**Application by Light Valley Solar Limited for an Order granting Development Consent for the
Light Valley Solar Project.**

Planning Inspectorate Reference Number: EN0110012

Deadline 1: Written Representation submitted on behalf of National Highways Limited

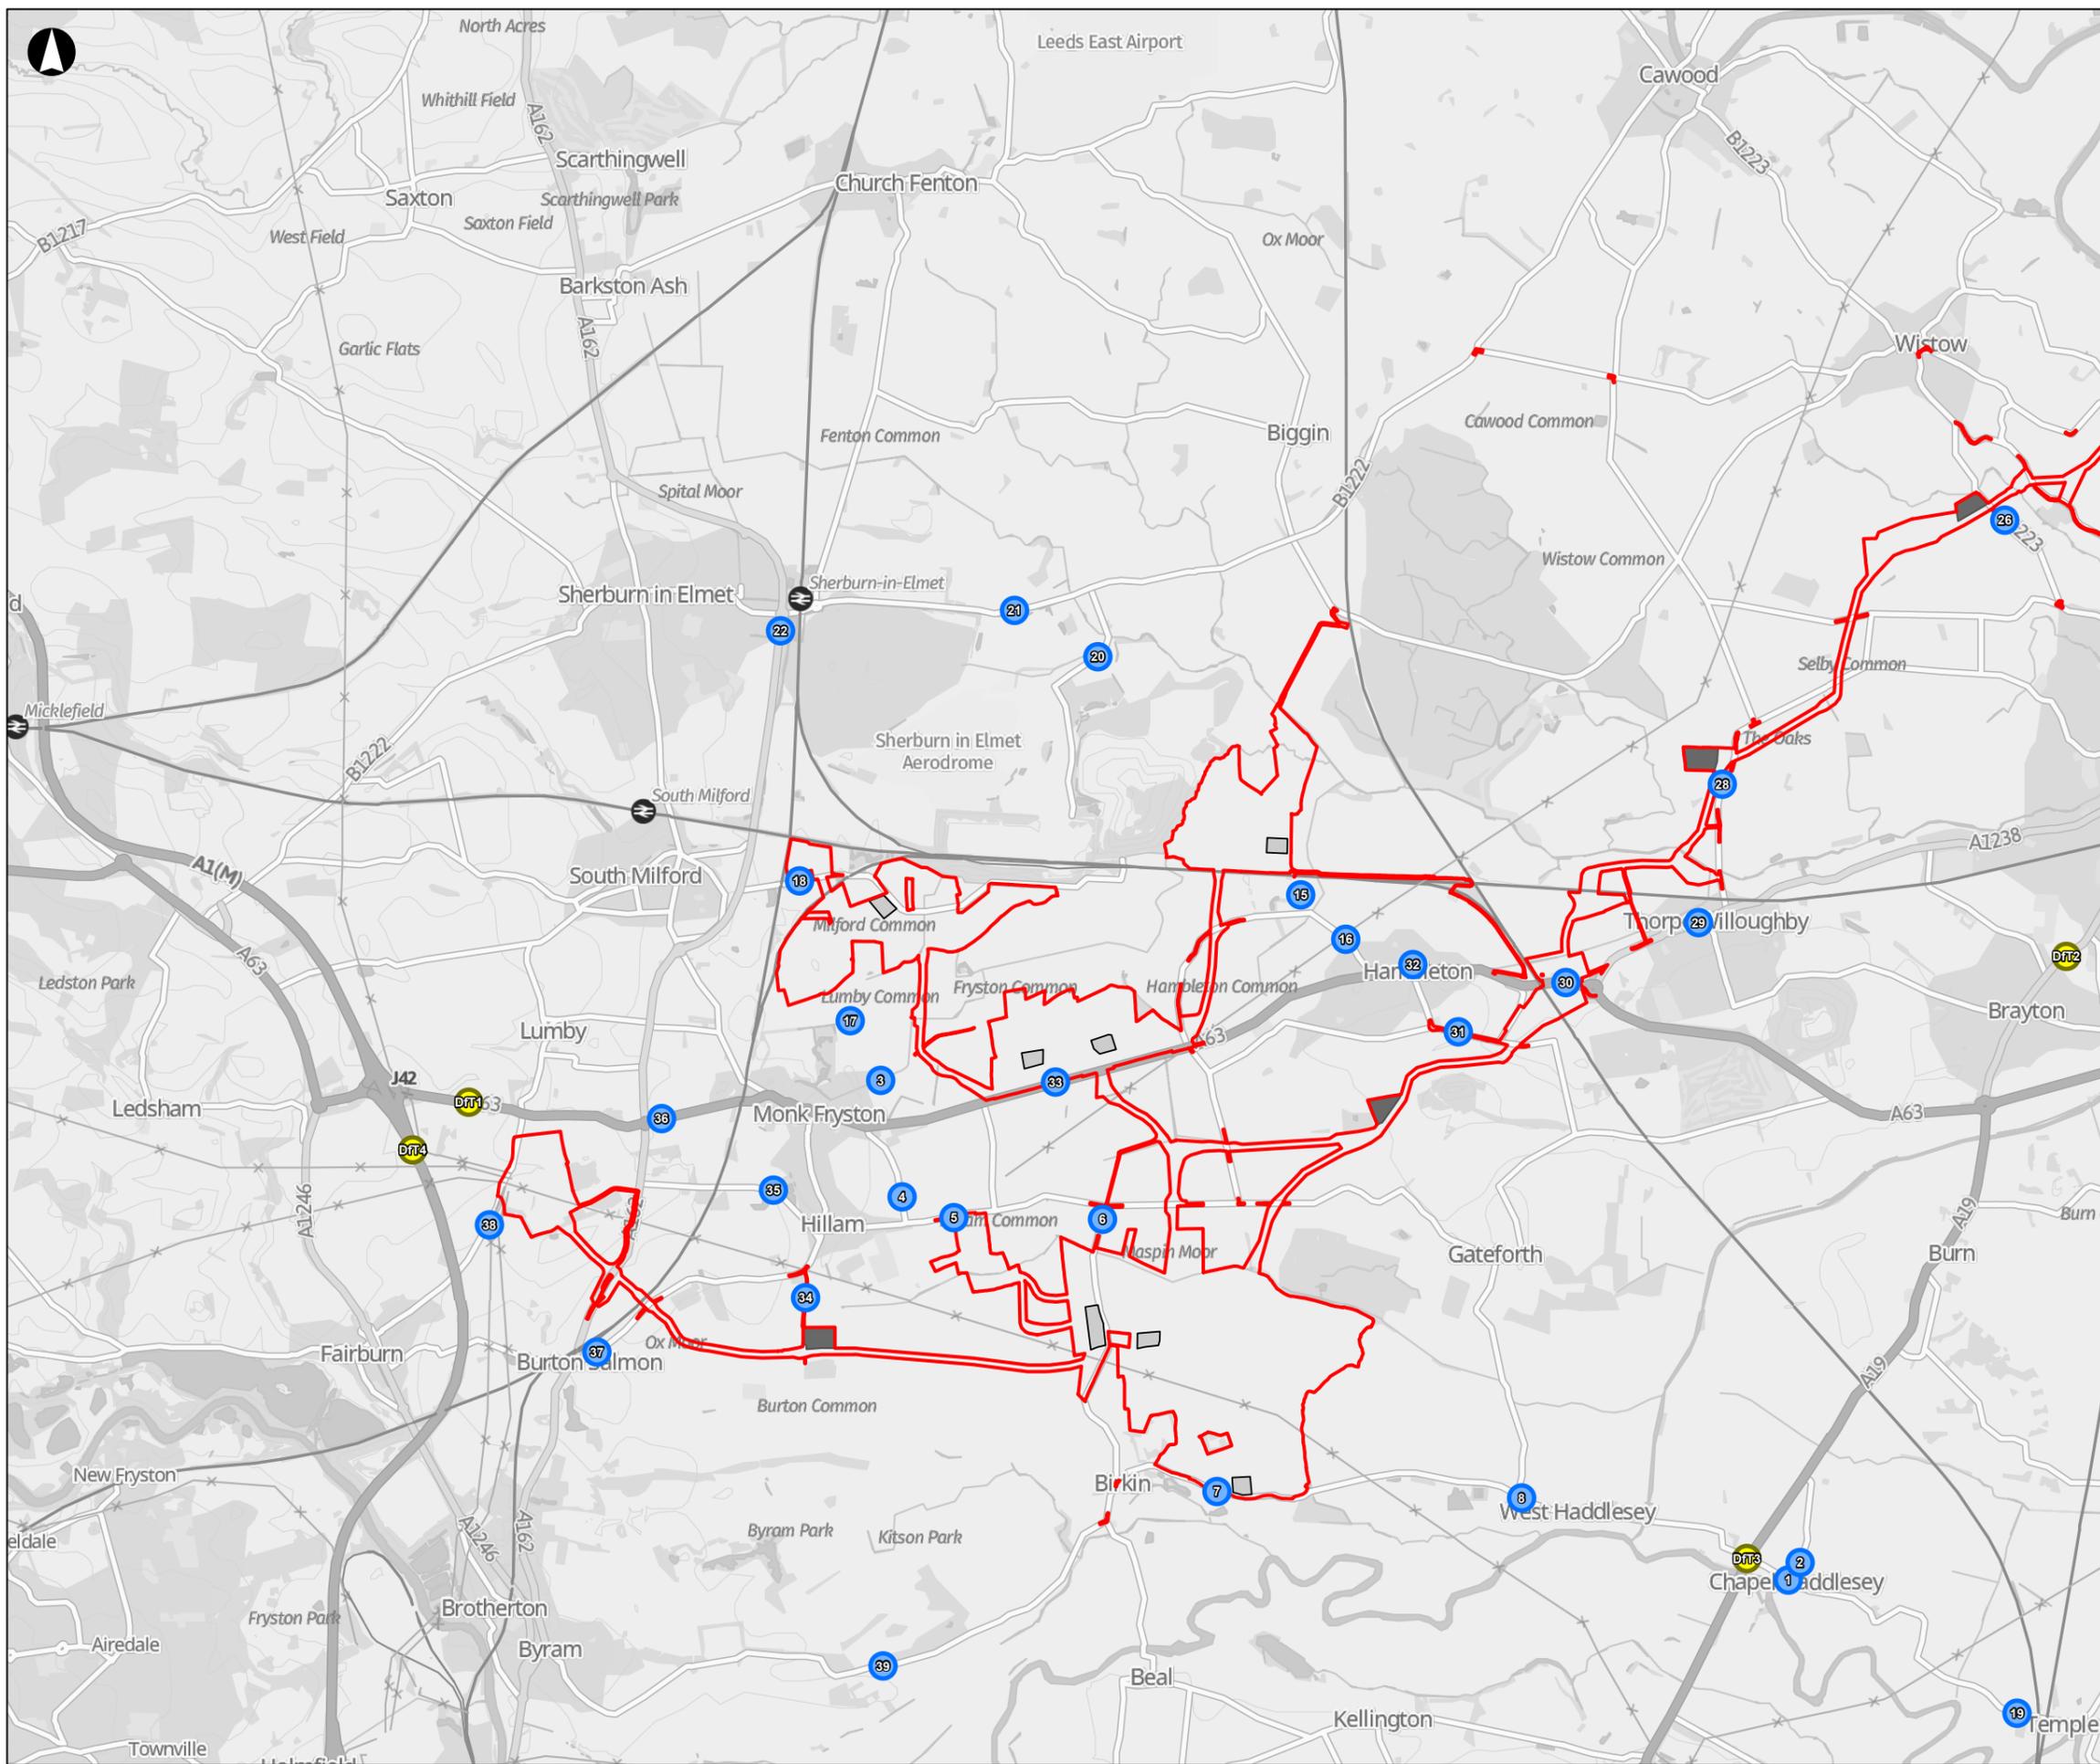
Relevant Representation Paragraph and Position	Updated Position and Rationale and any update to the Requirements
Traffic and Movement [APP-052]	
6.3 The Applicant should provide a detailed methodology for the TEMPro growth factors used to uplift baseline traffic data and forecast future baseline traffic flows.	Following correspondence with the Applicant, NH have reviewed Section 2.3 of the TA. NH note from Paragraph 2.3.4 that there will be traffic growth from the 2025 Baseline flows to 2029 which is predicted to be the peak of construction, with construction having commenced in 2028. In addition, the Applicant in its response in point 6.7 states that <i>“an estimated impact at the A1(M) junction of up to 20 additional trips in total (10 each way) during the highway network AM and PM peaks.”</i> NH consider that this quantum of movements on the junction is, therefore, unlikely to have a material impact on the operation of this junction.
